From: James Russell
Sent: 24 October 2012 16:17
To: Graeme Thorpe
Subject: Planning Application Consultation: 0578/P - Sagar Heys Park, Devils Elbow Activity Centre, Whalley Road, Read

Further to our site visit today, I confirm I have no objections in principle and recommend the following conditions be considered and attached to any approval;

drg.no. 11/26 PL 01 rev C

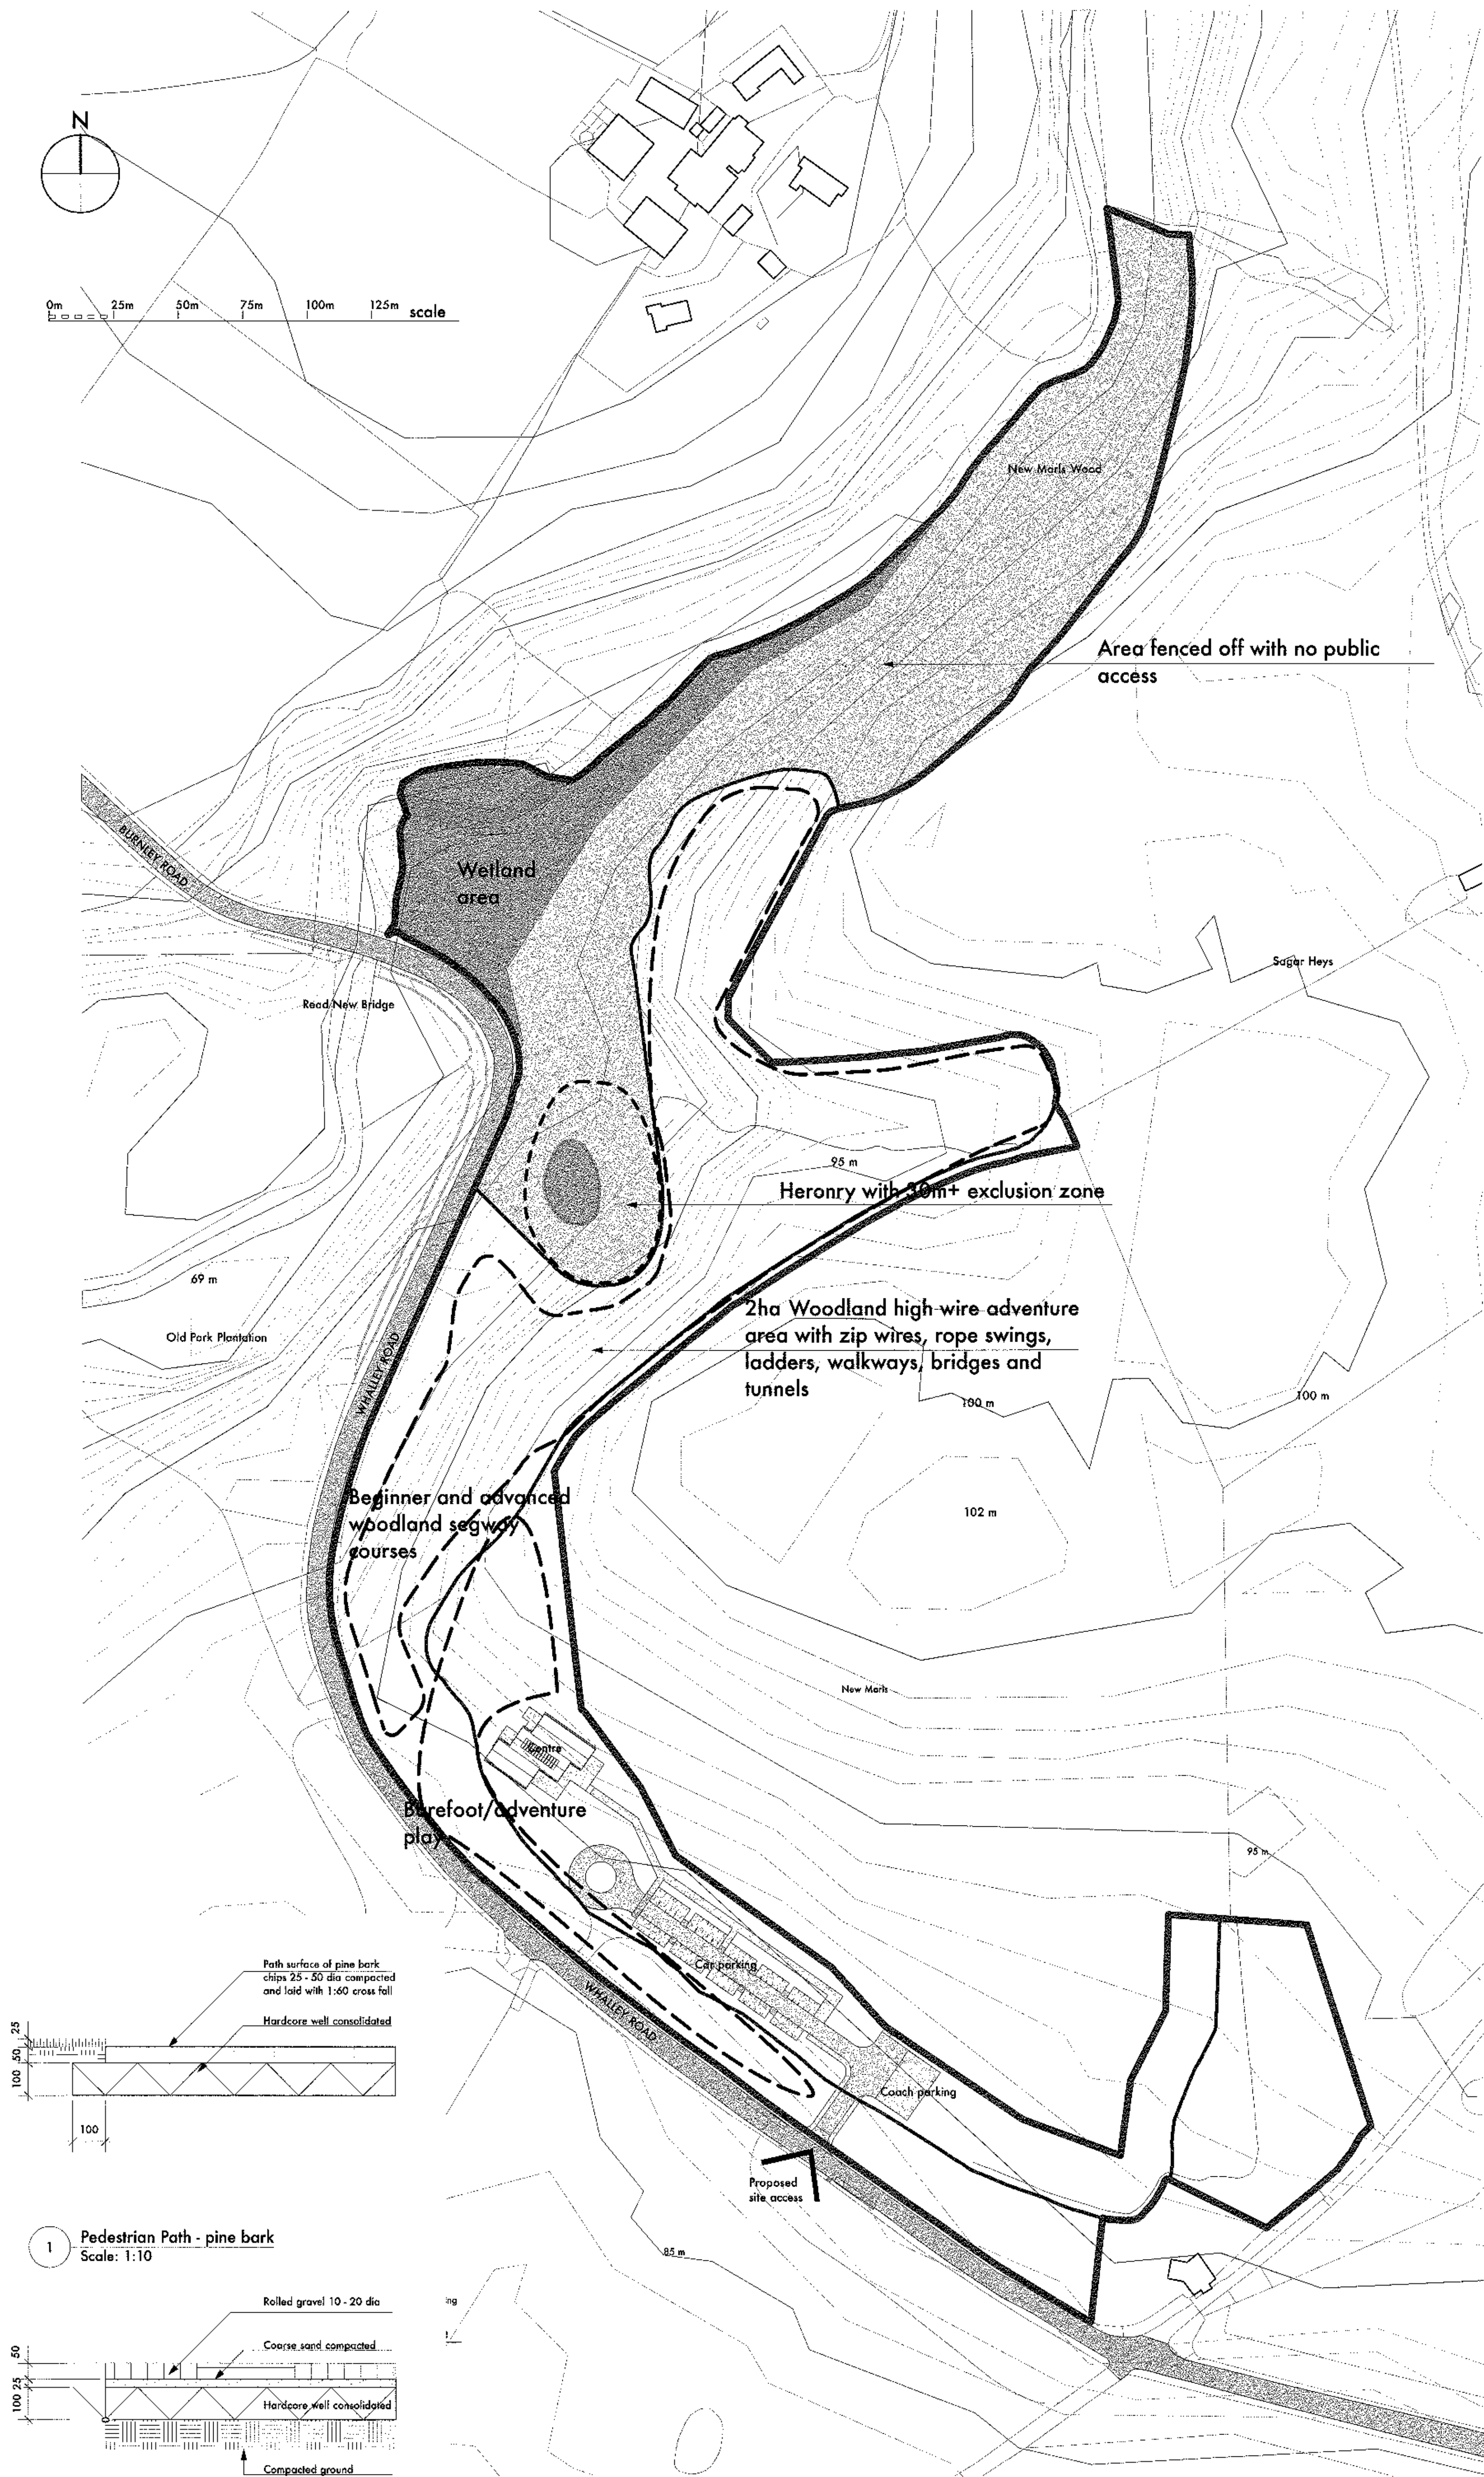
- Hours of Opening be restricted to 09 00 to 19.00 hrs between 1 April to 30 October, 1/11 to 31/3 be 09 00 to 'dusk'
- Provide solid screen fencing between vehicle parking and former gatehouse
- Due to potential noise disturbance off site, zip wires, rope swings, bridges be excluded from Northern sector of site
- Site lighting to be limited to car park and entranceway to centre. Site lighting to be designed to be inward facing so as not to illuminate beyond
